This submission objects strongly to Chatswood Option 3, while expressing qualified support for the Sydney Metro project, preferably St Leonards Option 2 (although “discarded” by EIS, p.78).

Issue 6: rail-bridge for T1 (6.4.2.)

Issue 7.3: noise barriers (6.9.3 & 11.4.2)

Figure 7-8 Chatswood dive site (northern) indicative layout

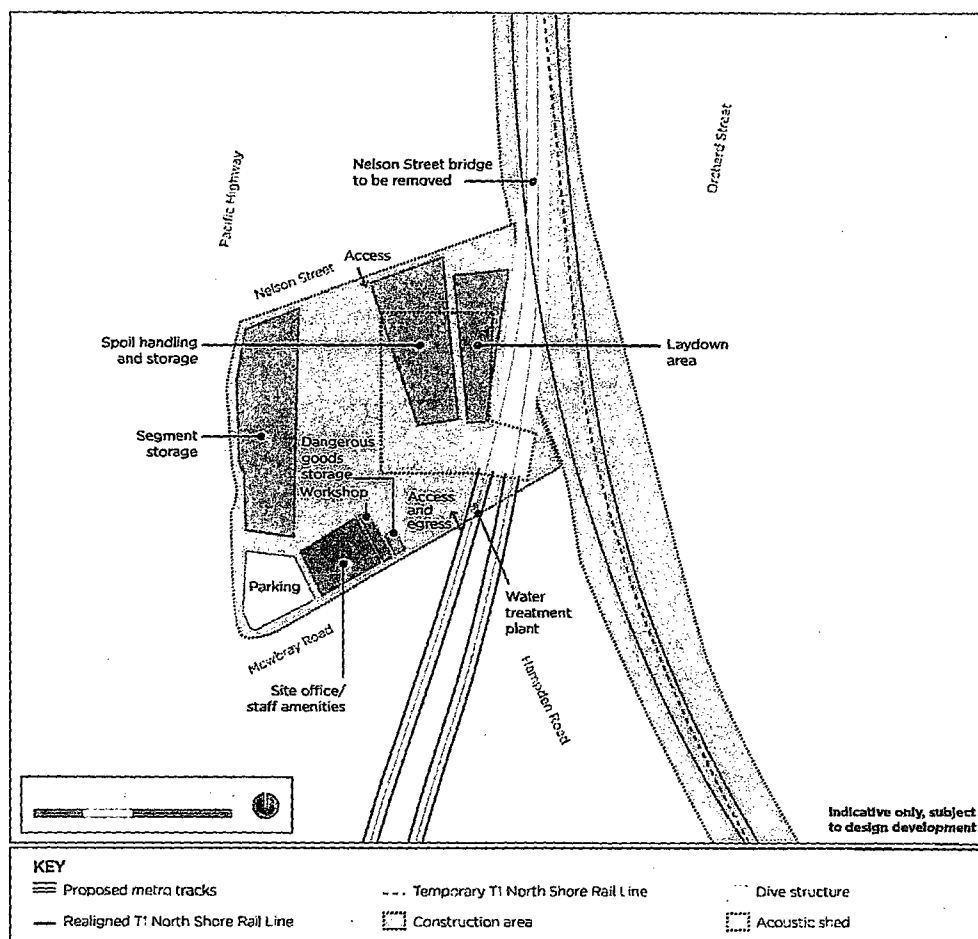
- The rail-bridge is not shown on Fig.7-7 (p.209) & Fig.7-8 (p.214), although they do show both the dive structure & T1.

*An artist’s impression should be provided showing a cross-section of both of the 2 major structures within the rail-corridor to be built alongside until the Ausgrid dive portal: showing the height of the 400m dive structure and the 60m rail-bridge which will have 100-300 meters long grade ether side. (p.213)
